SUBJECT: Tekin Mini-Warehouse

RE: GRADING & DRAINAGE PLAN FOR MINIWAREHOUSE UNITS @
INDIAN SCHOOL ROAD & WYOMING BLVD. NE (H20-D13)
RECEIVED APRIL 17, 1984

DRAINAGE / GRADING PLAN
MINIWAREHOUSE UNITS
INDIAN SCHOOL & WYOMING N.E.

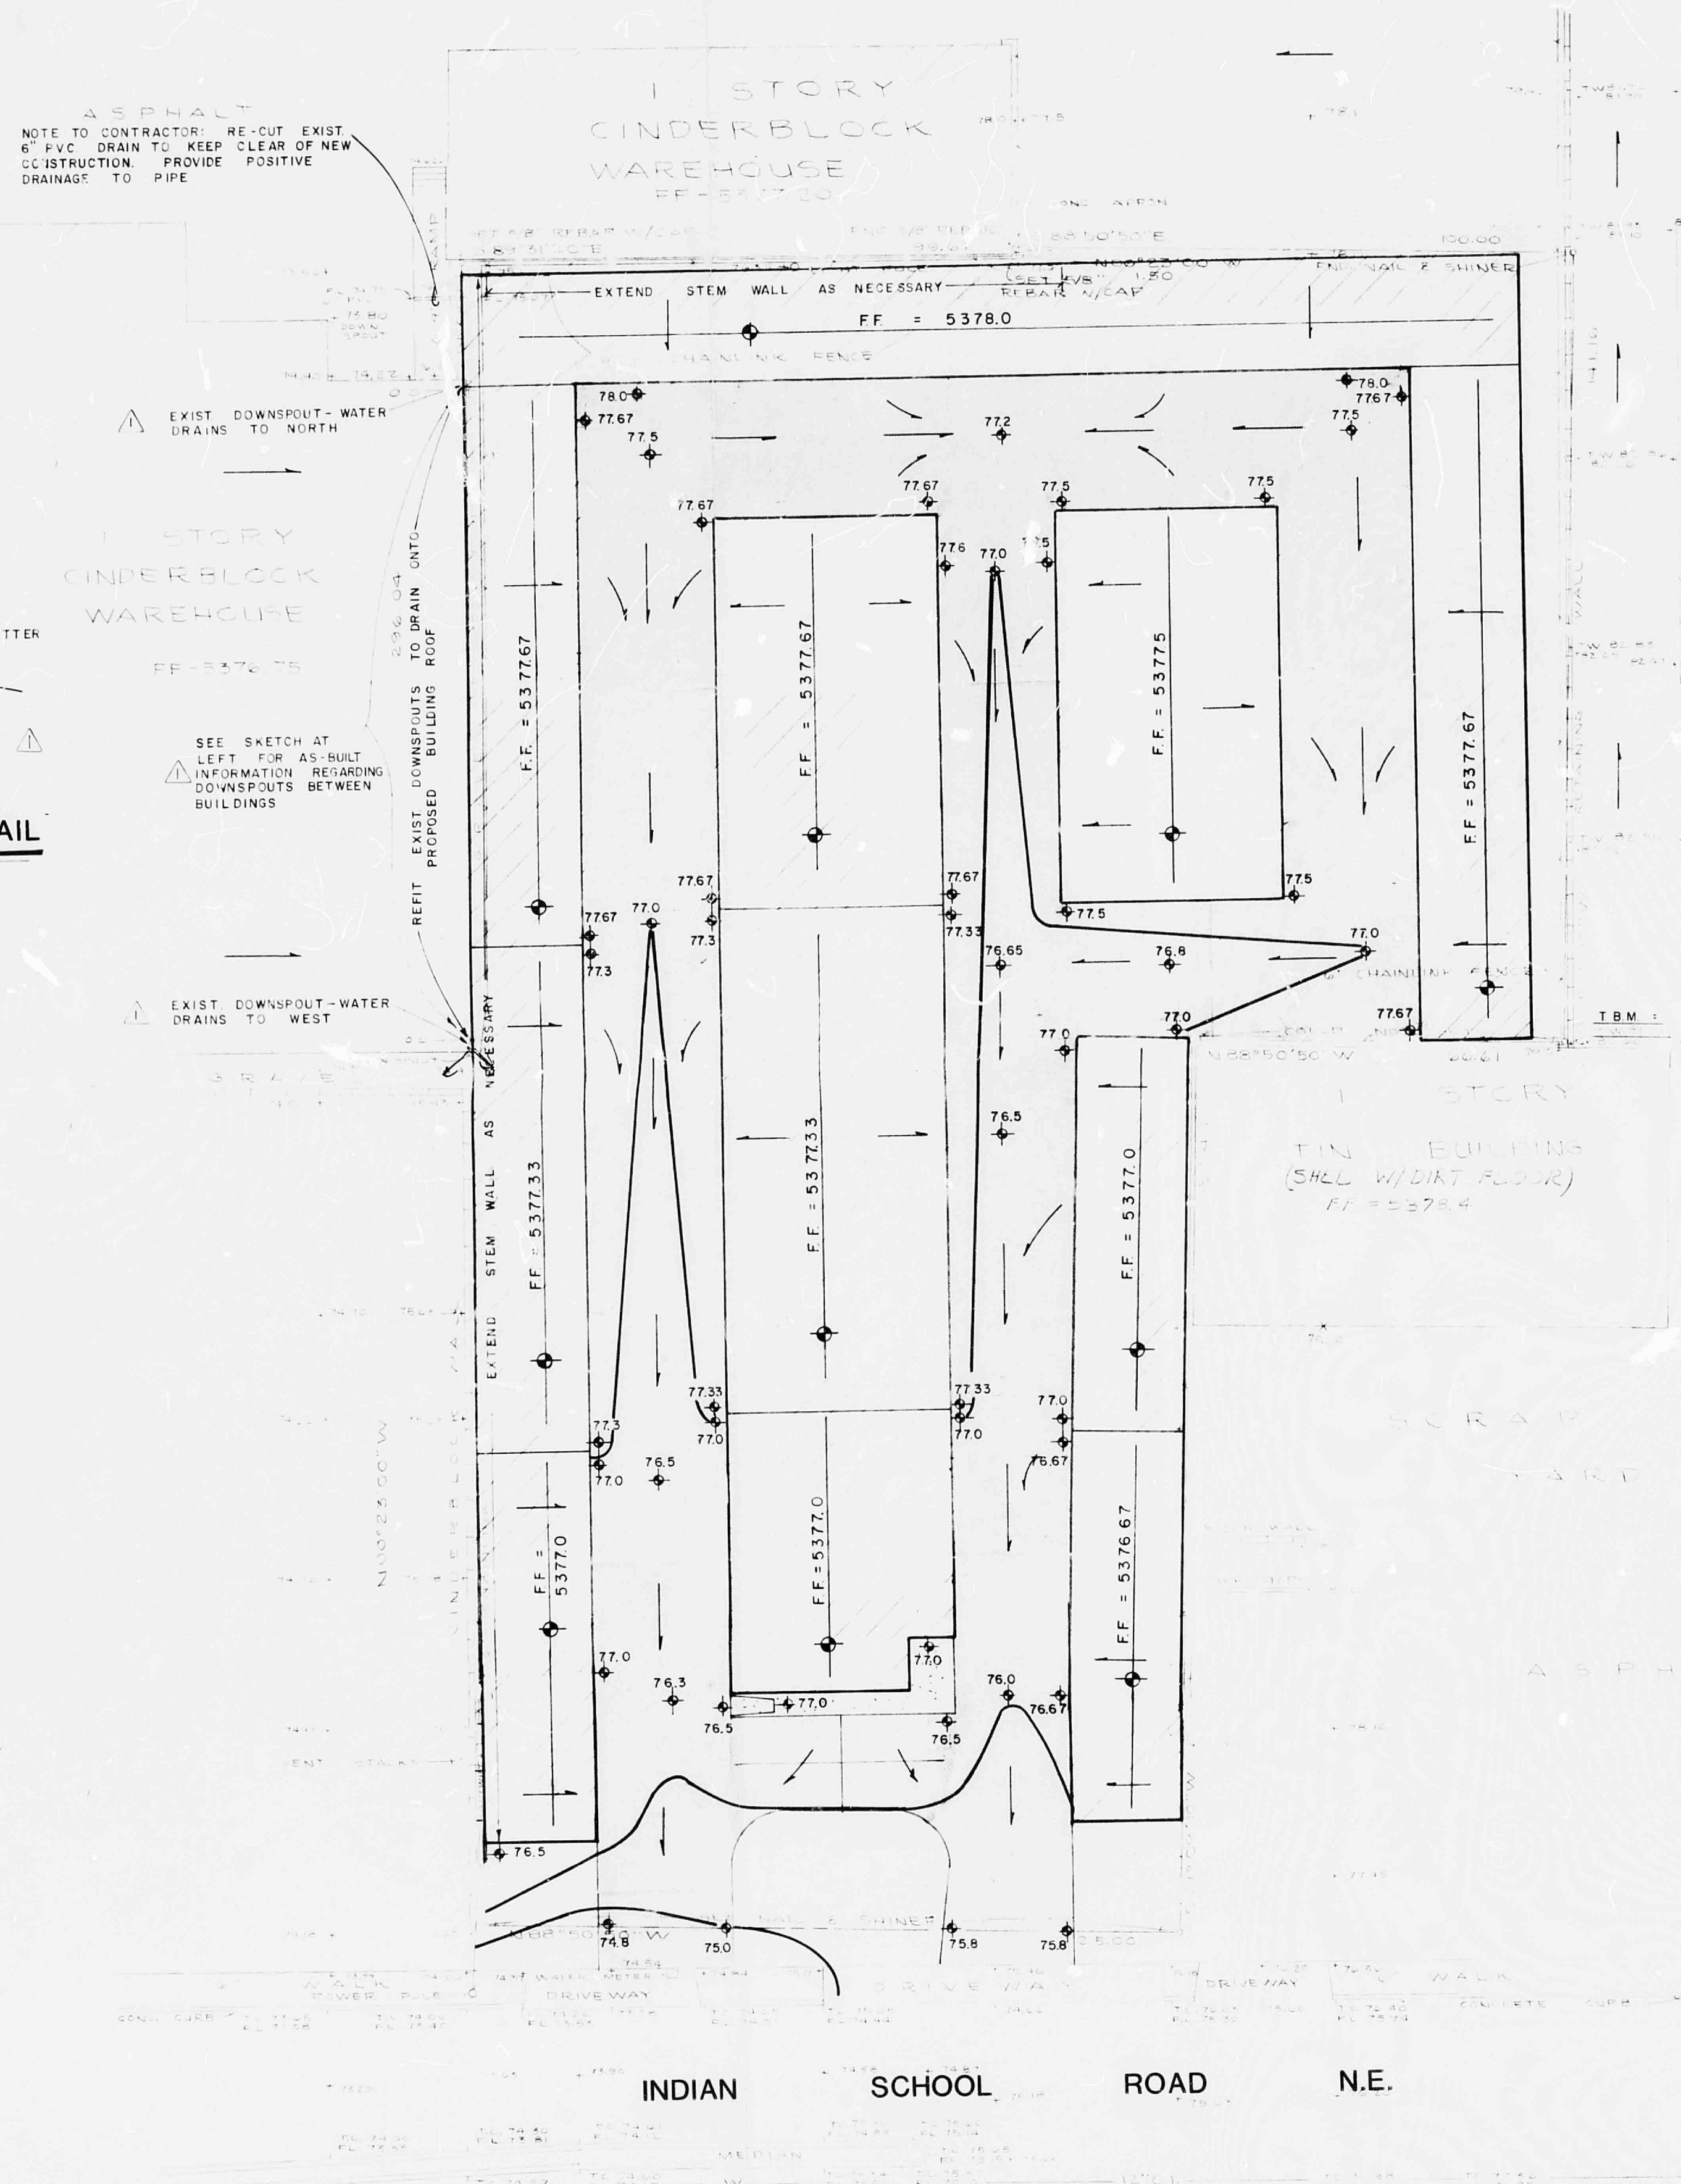
1. It is stated that there are no off-site flows, yet, the plan indicates that the adjacent building will drain onto this site. This needs to be quantified and added into the on-site runoff.
2. The building in the NW corner is covering up an existing 6 inch P.V.C. drainline on the adjacent property. What is the purpose of this drainline and what impacts will result from the proposed use deletion?
3. What happens in the area between the east building and the wall at the east property line? Will water pond in this area?
4. What is the F.F. elevation of the 1-story tin building adjacent to the east property line?
5. Spot elevations on the asphalt for the east property indicate this area to be higher. What prevents runoff from this east area onto the site, hence, off-site flows?

- ✓ 6. Spot elevation adjacent to the north property line indicate that water ponds against the off-site building on the north and the on-site north building.
